Recommendation Report for Planning Permission for Works or Extension to a Dwelling

REF NO: AW/295/18/HH

LOCATION: 9 Aigburth Avenue
Aldwick
PO21 3DA

PROPOSAL: Conversion and extension of existing garage to craft/store and demoliton of existing conservatory to include alterations to fenestration

03

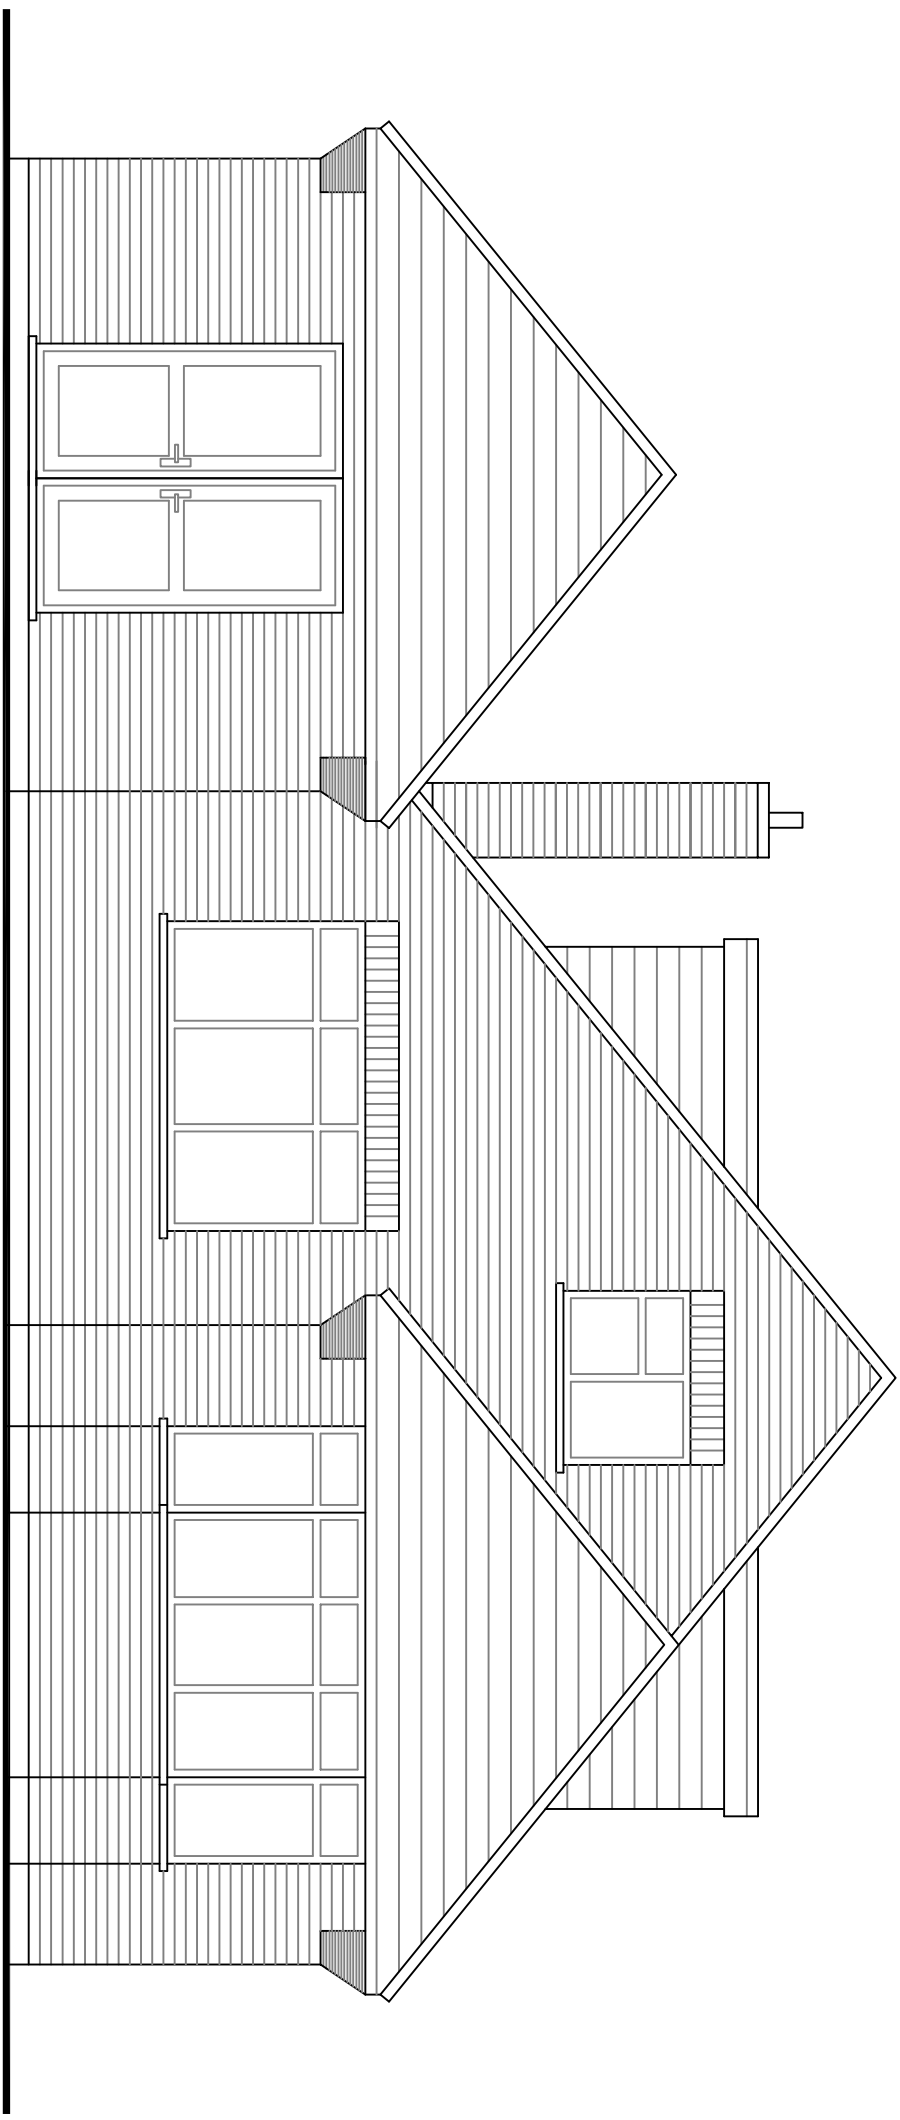
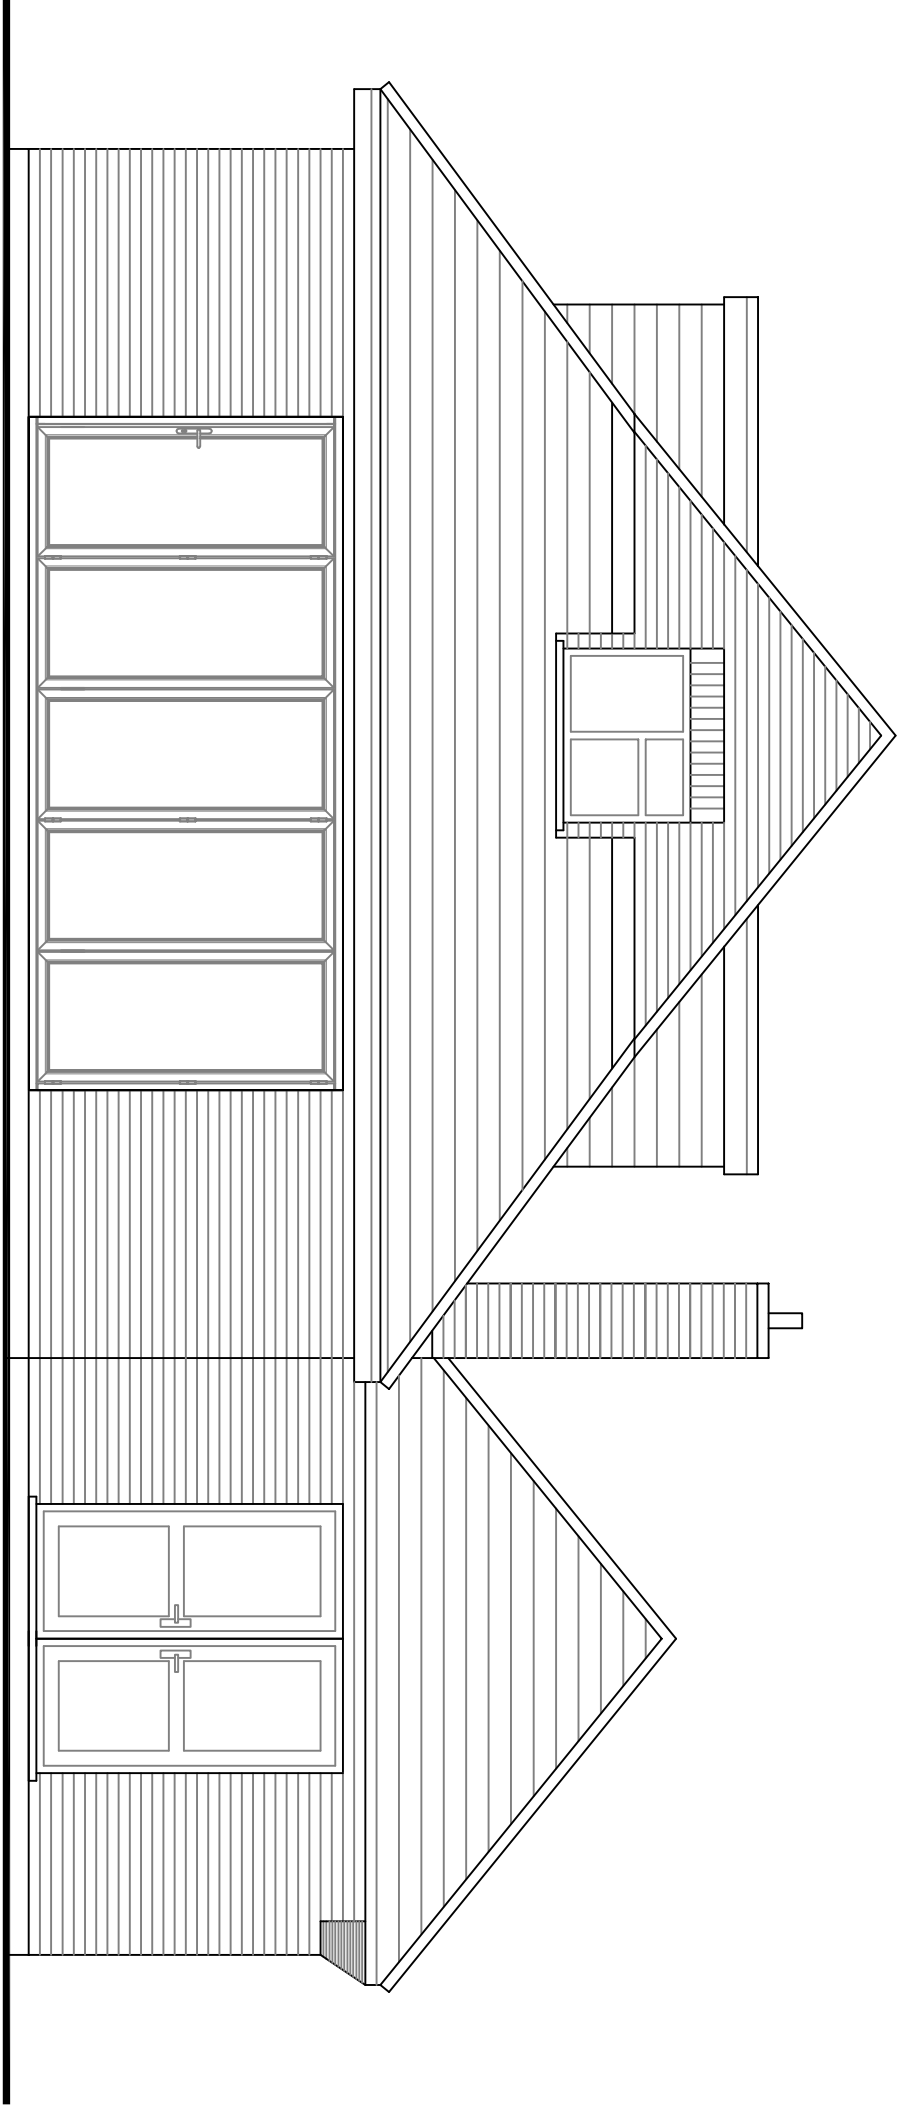
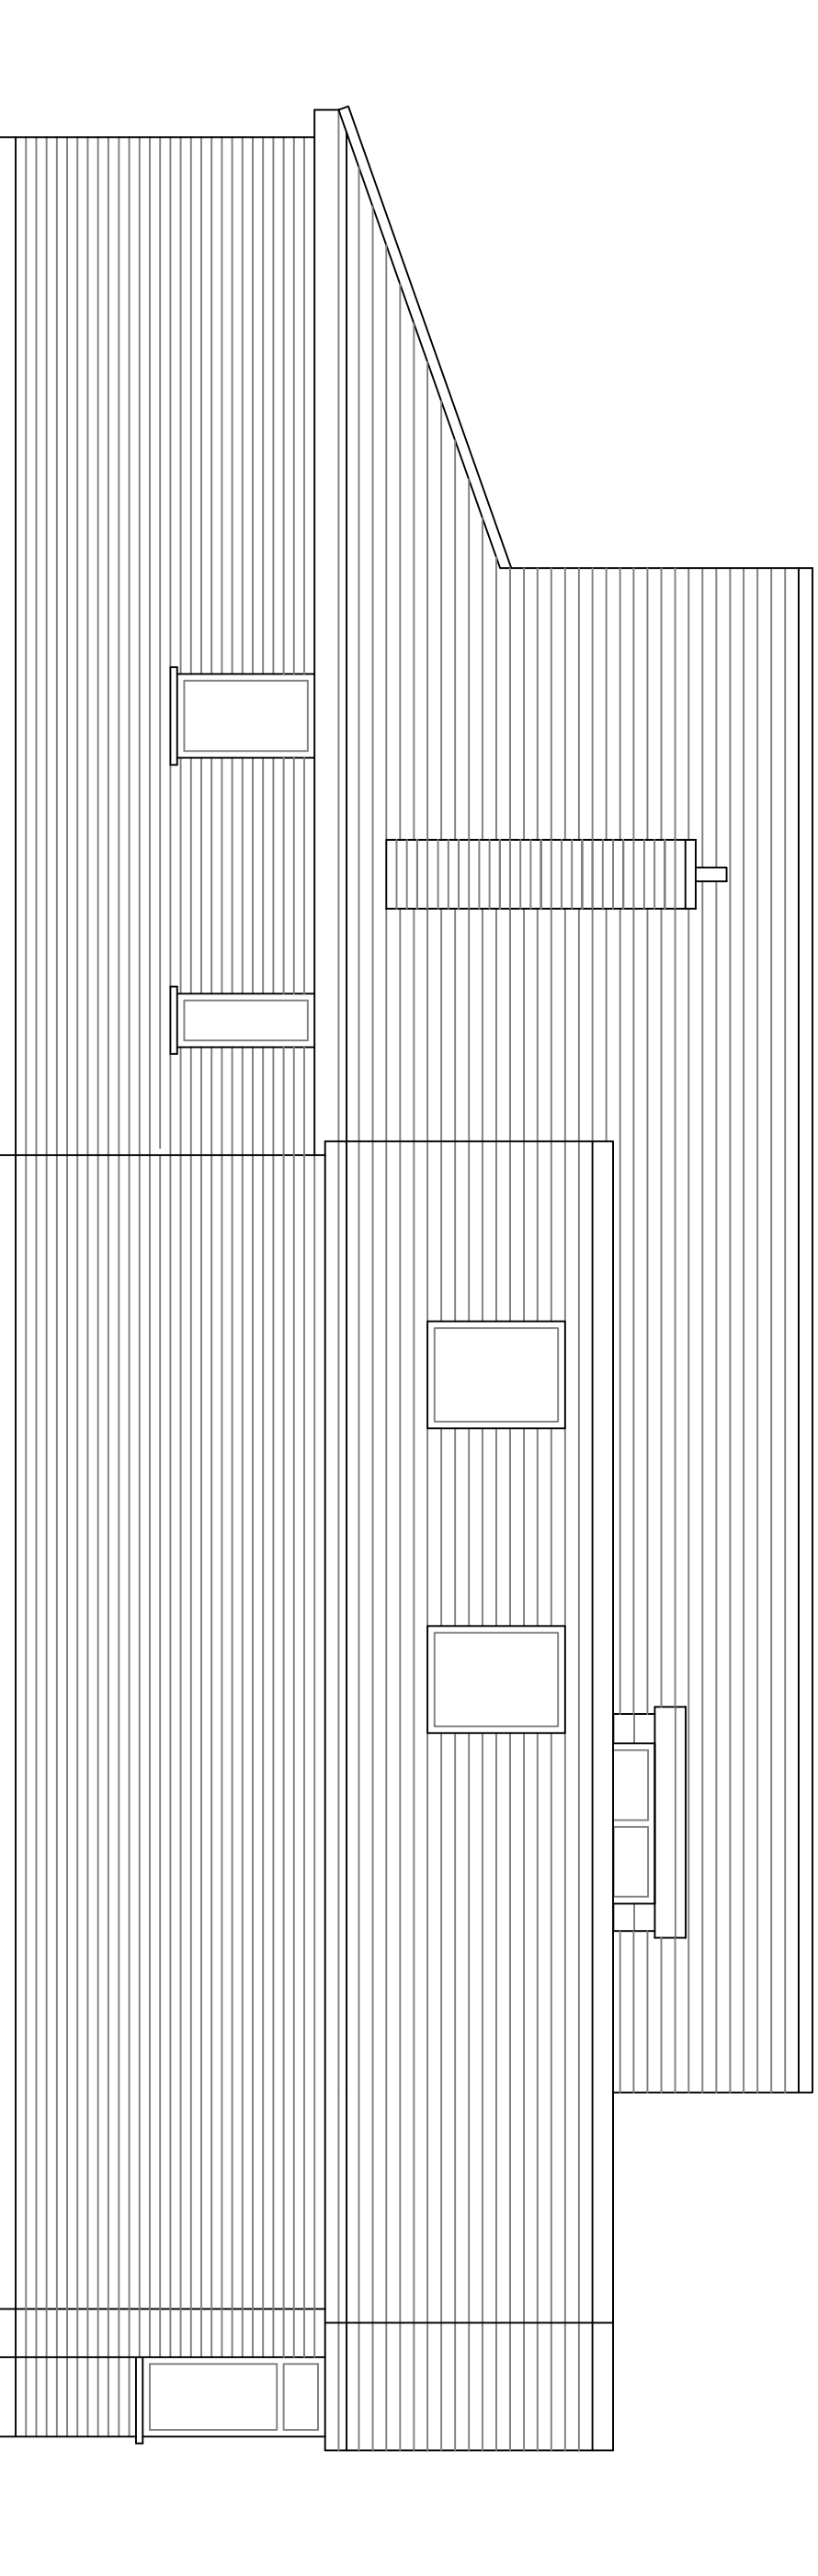
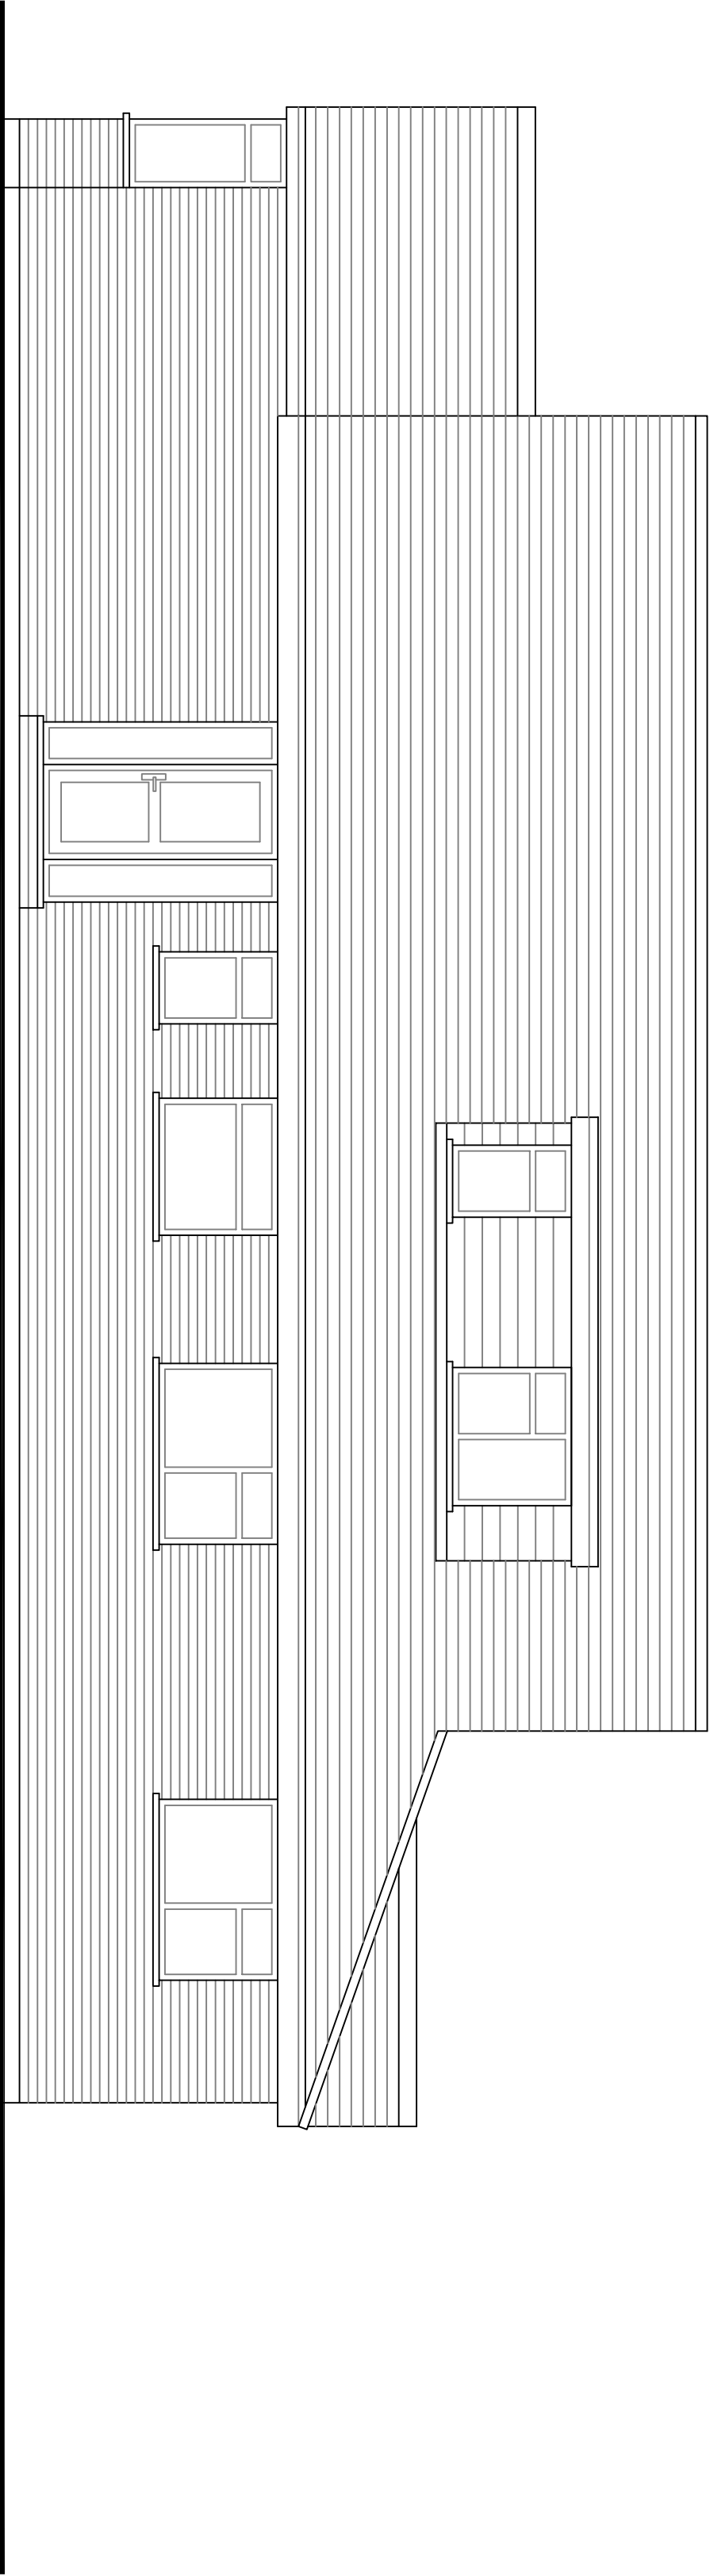
The proposed demolition of the existing conservatory forms the other aspect of the application. This create 1No. window to the North elevation and include Bi-fold doors the West Elevation.

The alteration to the front elevation which will consist of changing garage doors to double doors opening into a store. It is not considered that the alteration of the doors would cause any unacceptable adverse impacts to the neighbouring properties.

The proposed demolition of the existing conservatory will also consist of Bi-fold doors to be installed to the rear elevation, the doors due to there location are not considered to give rise to any overlooking. There is a window proposed on the Northern elevation the proposal will be approximately 1.8m from the Northern boundary, however, will be no closer to the boundary than the existing dwelling and given the separation distance of approximately 10m from the adjacent dwelling to the boundary it is not considered to cause any unacceptably harmful impacts on neighbouring properties.
